We refer to the proposed redevelopment of Oxford and Verona Street, for which application for approval was submitted under State Significant Development Application SSD 87245208. This letter provides responses to further information required by Heritage NSW and Sydney Water which must be addressed as part of the Response to Submissions (RTS) package to DPHI.

Table 1 Response to RFI

Project
Verona, Paddington

Figure 8 Proposed Section

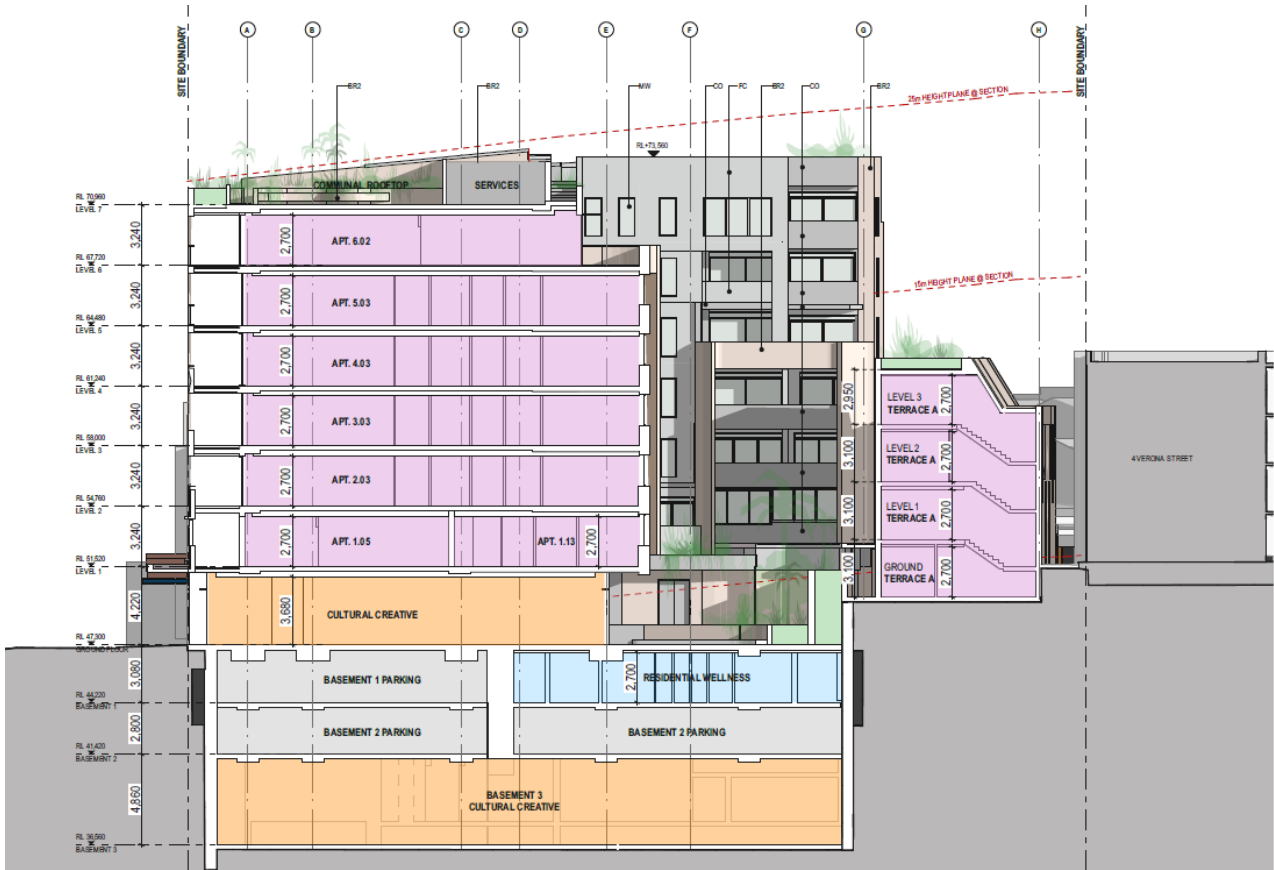
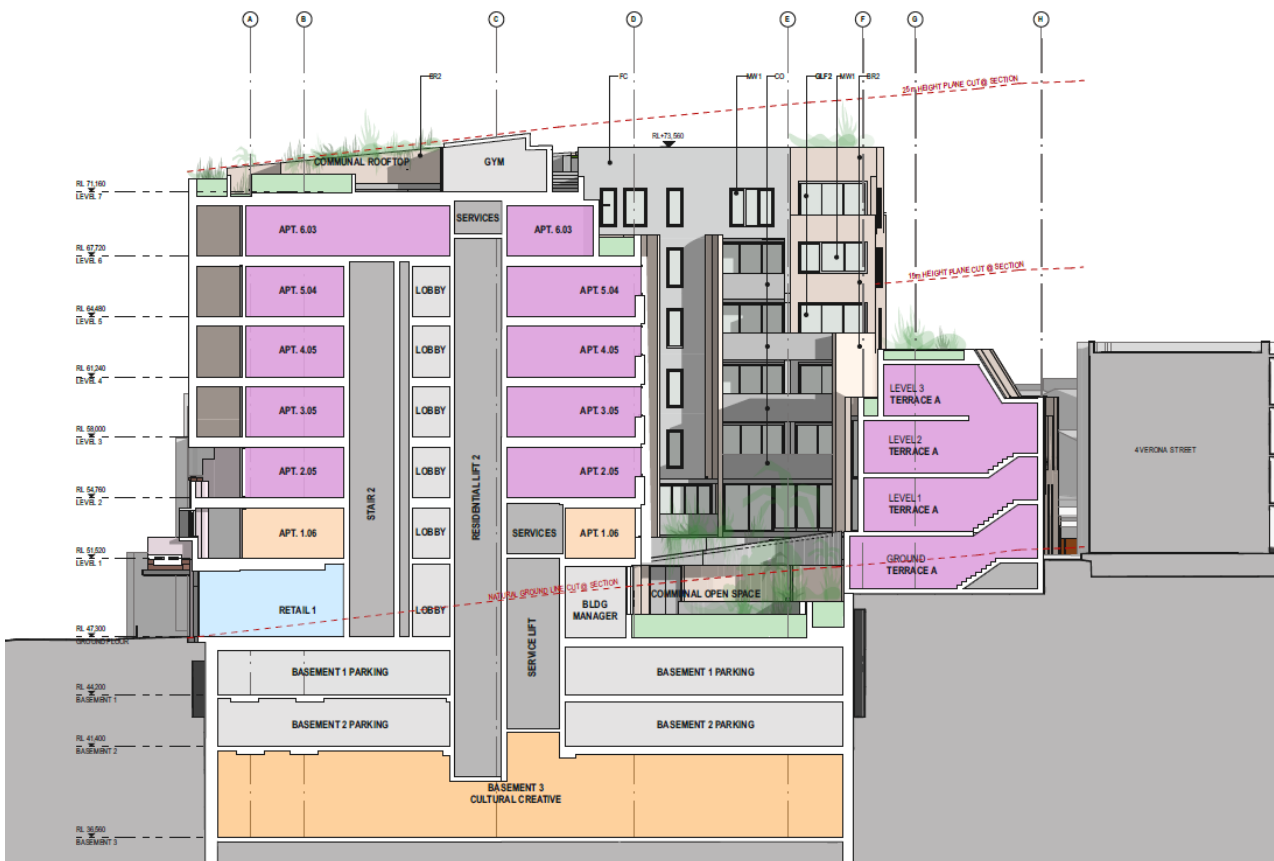
- a)** The proponent should show the location of Busby's Bore in the Section plans, demonstrating the proposed separation from basement excavation and construction and relative depth compared with the proposed new building basement levels.
- b)** The proponent should provide Sydney Water with their construction methodology for review by the Sydney Water Heritage Team – this methodology must outline how Busby's Bore will be protected from potential impacts during excavation and shoring/piling works and throughout construction and beyond. The methodology must demonstrate how Busby's Bore

a) The Section Plan – Cultural Creative & Courtyard (see page 6) dated 10/04/2026, Drawing No. A 207 provided by TZG shows the location of Busby Bore and curtilage in relation to the proposed basement works.
